Application by Springwell Energy farm Limited for an Order Granting Development Consent for the Springwell Solar Farm

Summary of submissions on behalf of Lincolnshire County Council

ISH1 7 May 2025

DRAWING TITLE:  
**PROPOSED TYPICAL FIELD ACCESS**

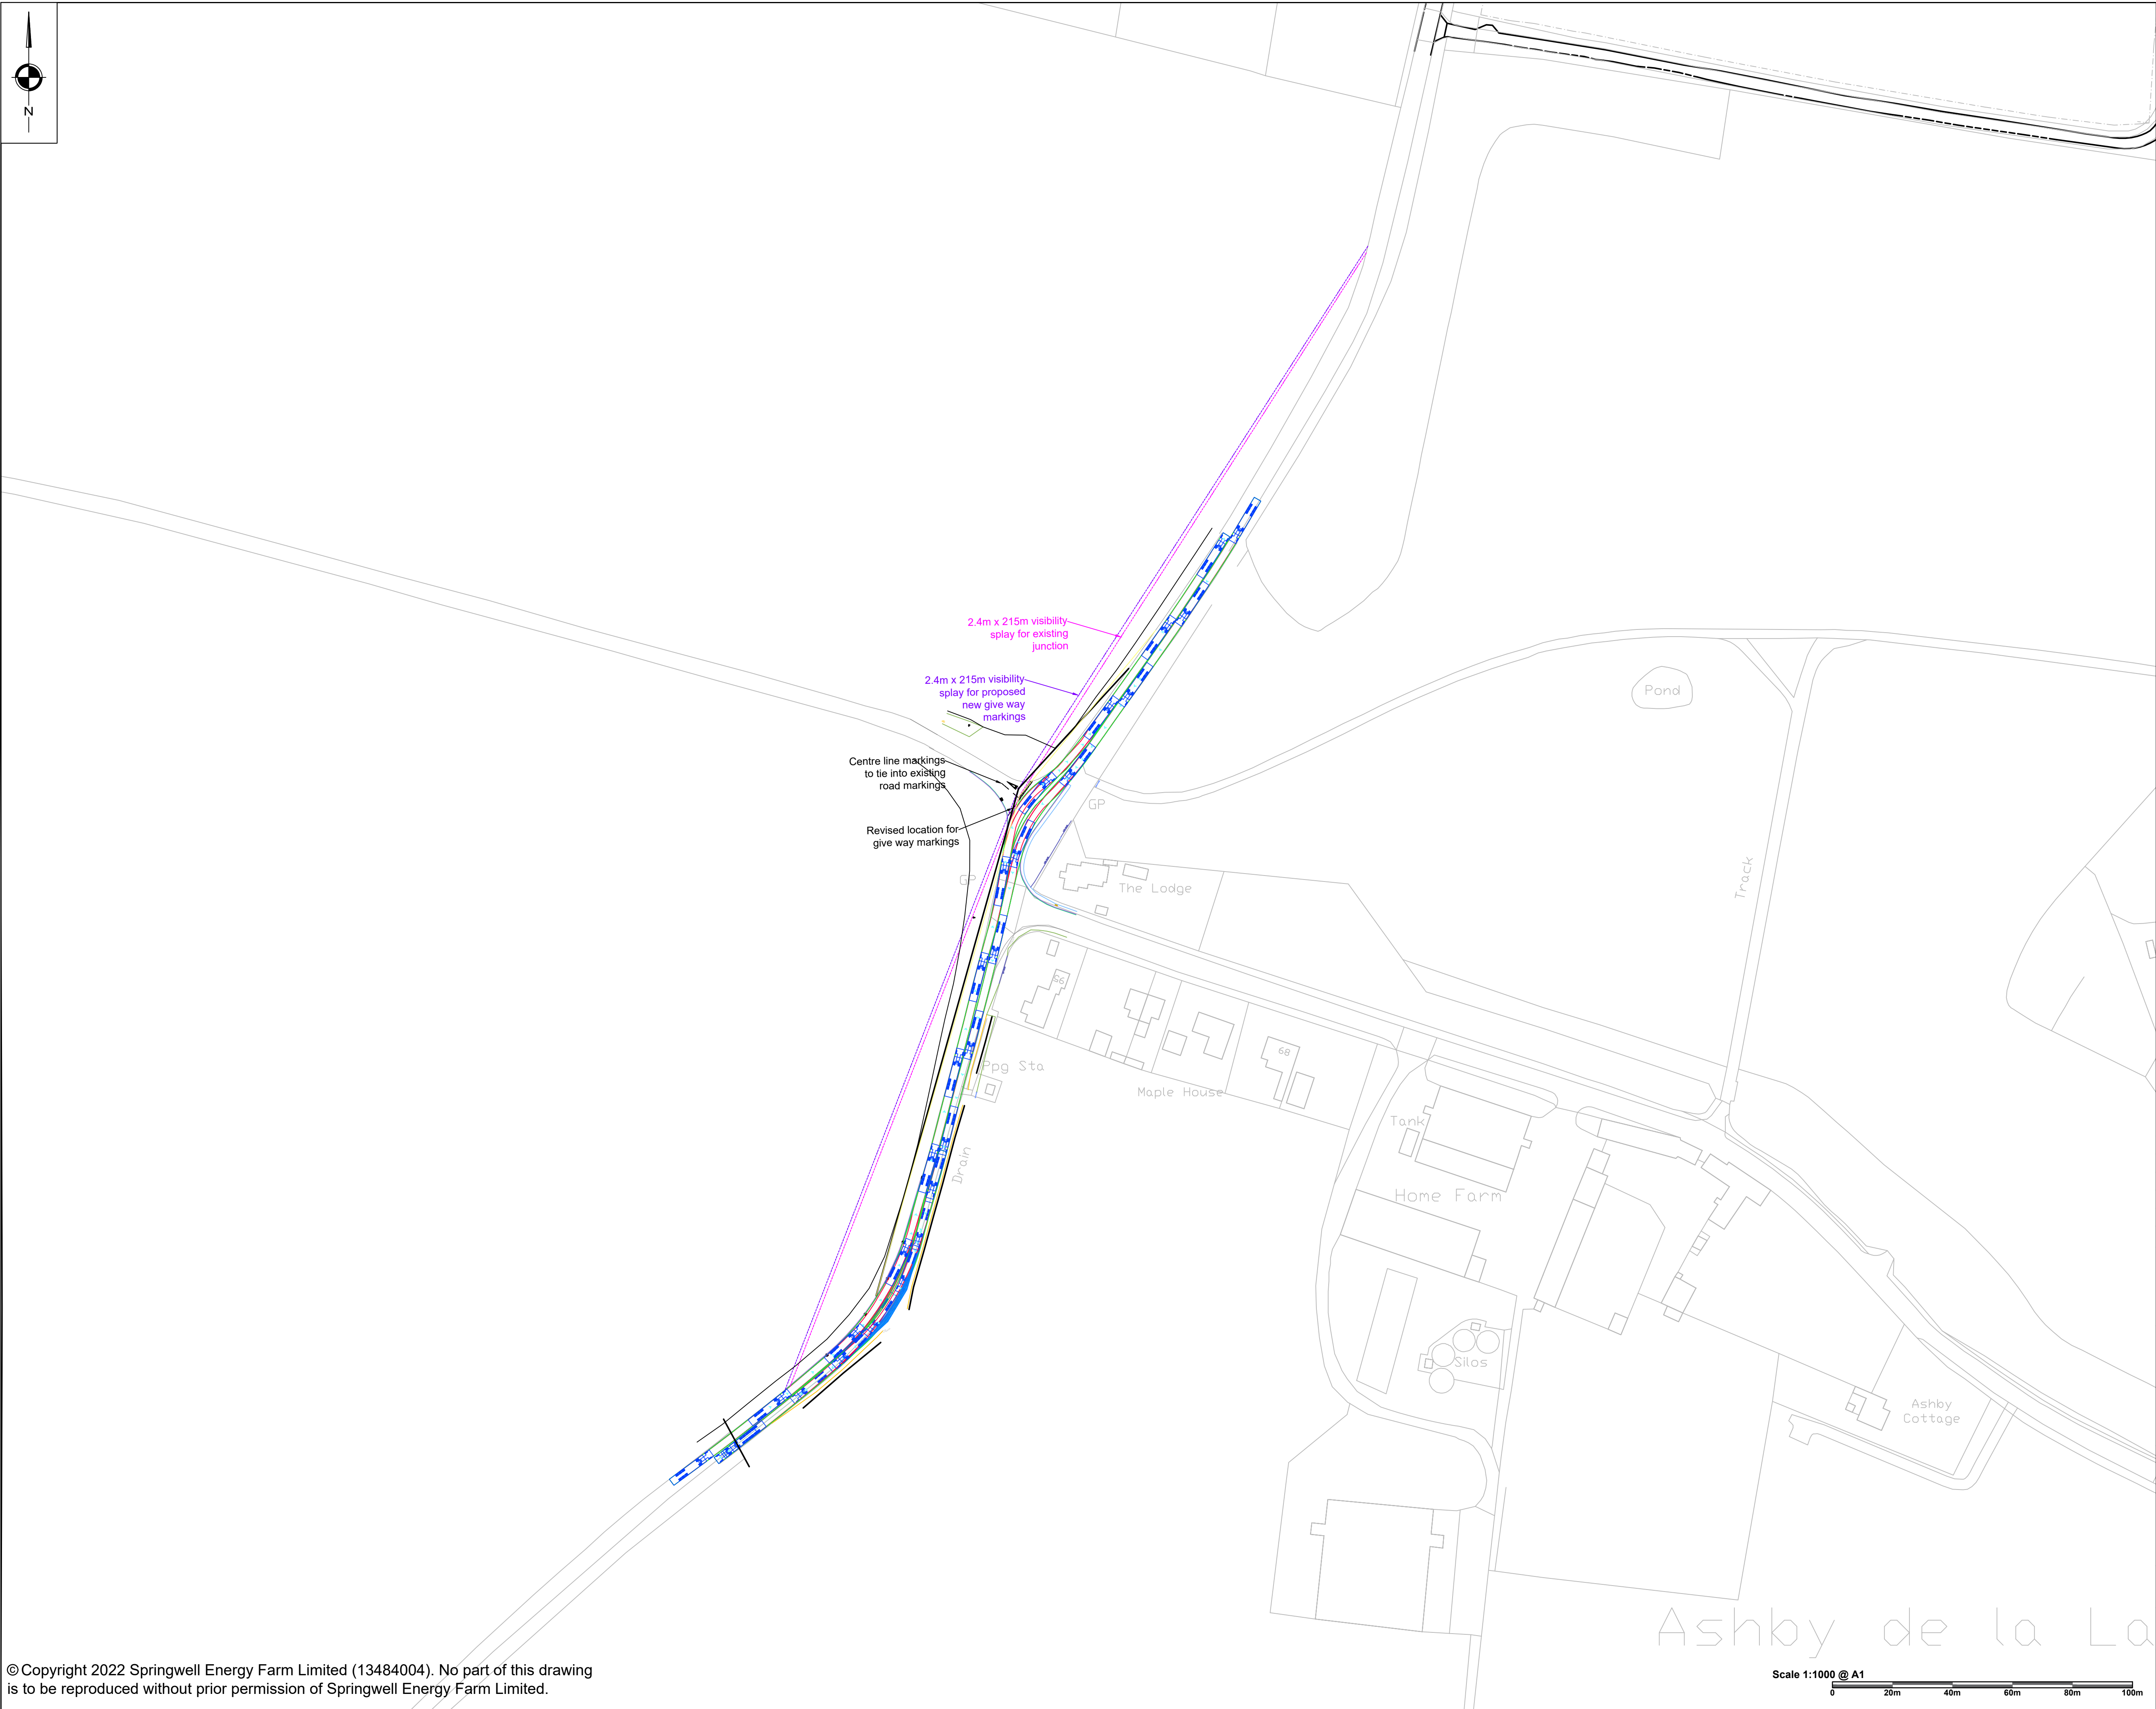
18. In response to the ExA questions about level of detail on submitted drawings. The level of details for the access junctions should be improved to show details of visibility splays and swept paths. The indicative nature of the drawings also means that the amount of hedgerow to be removed isn't determined at this stage, which could have an ecological impact.

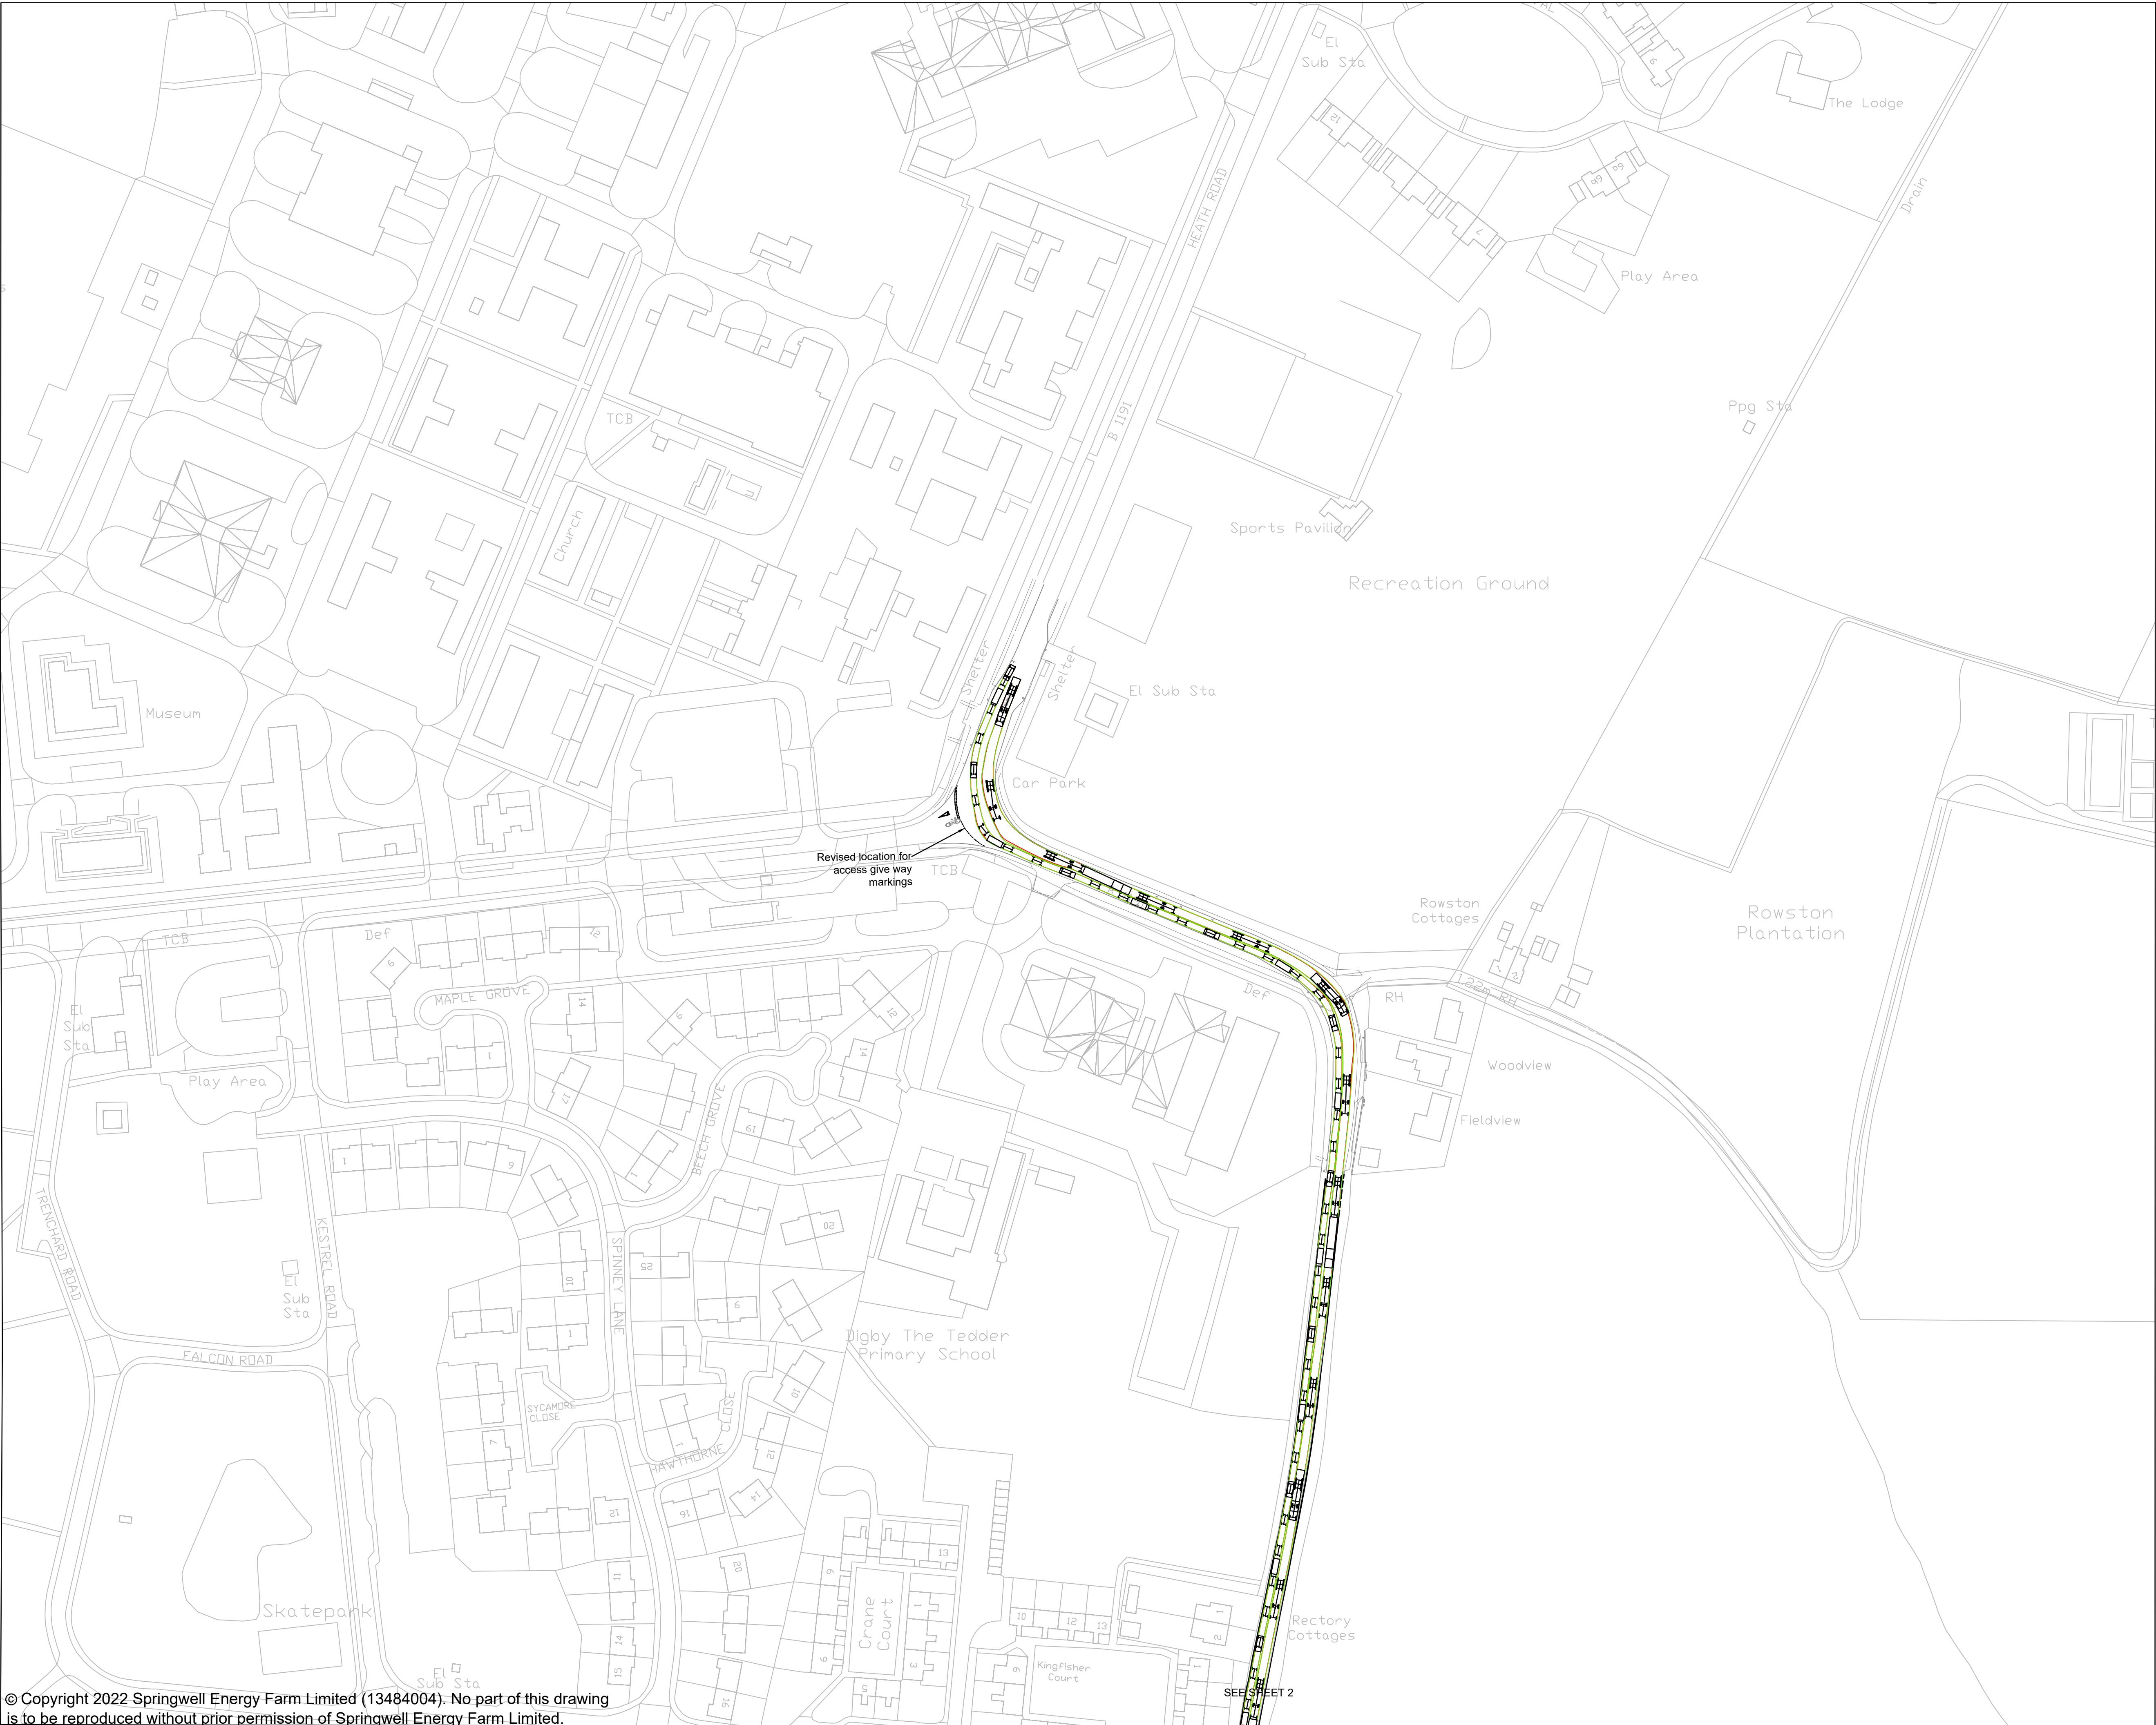
16. In respect of highways improvements, LCC confirmed that the 2 junction improvements on the A15:

- Gorse Lane/A15
- B1191/A15

will require a legal agreement with LCC for the technical checking, approval and inspection. A bond will also be required to cover the cost of the works in case a developer stops and LCC has to step in and make the highway safe by completing the works. The traffic risk at these 2 junctions is high due to the nature of the roads and the volume of traffic.
